DECISION DELEGATED TO HEAD OF PLANNING

Application No: H06-0829-22 **Applicant:** Mr R Lorenze
Proposal: Proposed rear extension
Location: 14 Bramley Meadows Gedney Spalding
Terminal Date: 13th October 2022

EAST SIDE ELEVATION
PROPOSED
1:100

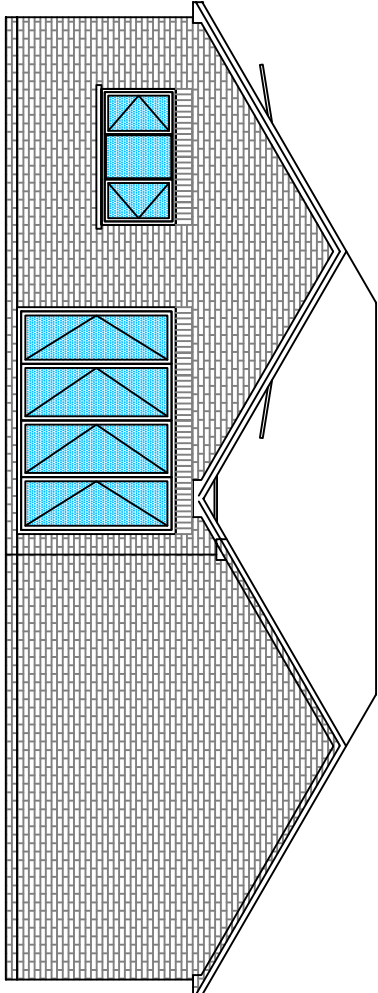
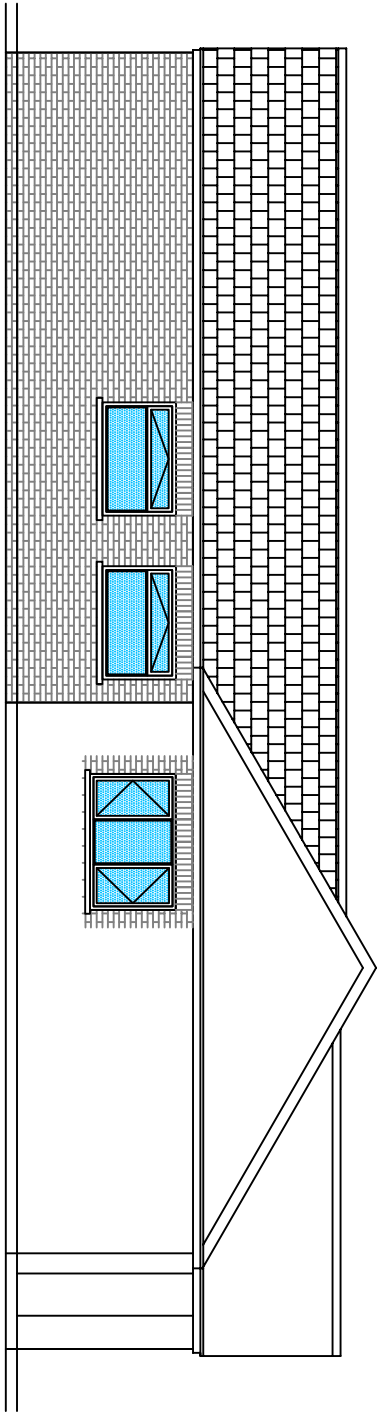
The extension would be located to the rear site therefore there would be limited views from the main public realm. The extension is considered proportionate to the existing bungalow and given its height does not exceed the roof ridge of the existing bungalow it would not appear overly prominent. The use of matching external materials would ensure the extension is in keeping with the existing bungalow.

A local councillor and the parish council has objected to the scheme on grounds that the proposed extension would cut out light to numbers 10, 12 and 16 and the patio doors would look into the kitchen of no.10. the neighbours at no.10 and 12 have also objected on this basis. The concerns are noted and discussed further below.

PROPOSED FLOOR PLAN
1:50

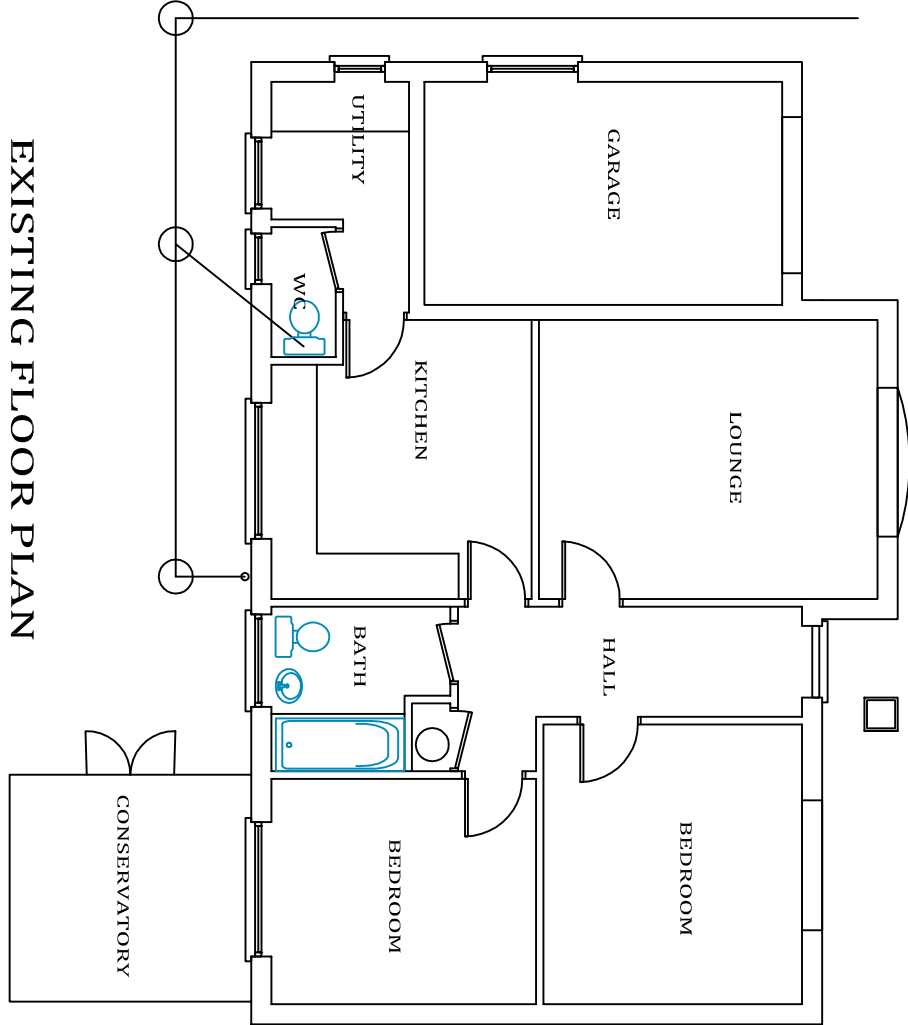
Objection as the development results in overdevelopment of the site and the size of the extension will cut out light to numbers 10, 12 and 16. The patio doors would look into the kitchen of no.10.

- Overbearing impact
- Overlooking from the doors in the side elevation
- The extension is out of character due to its significant footprint
- The extension would reduce light into neighbouring property due to its height
- Delivery of construction materials has already caused damage to the service road pavement

The proposed extension would sit adjacent to the rear gardens of no's 10 and 12. Given the relationship with these neighbours it is not considered that any overbearing impact or unacceptable overshadowing would result. With regards to concerns of overlooking from the patio doors, the concerns are noted, however given the high level boundary fencing there would be limited views from the proposed patio doors. As such any impact would be within acceptable tolerances.

With regards to the neighbour to the west at no.16 the proposed extension would be sited approximately 2.2 metres from the shared boundary with this neighbour and some 4.6 metres from its nearest elevation. The proposed extension would have an overall rear projection of 8.6 metres (5.4 metres beyond the existing conservatory). It would extend approximately 4.6 metres beyond this neighbours rear elevation closest to the application site. Given this, the separation distance and the fact this neighbour does not have any primary windows in its side elevation facing the application site no unacceptable impact is considered to result on the amenity of this neighbour.
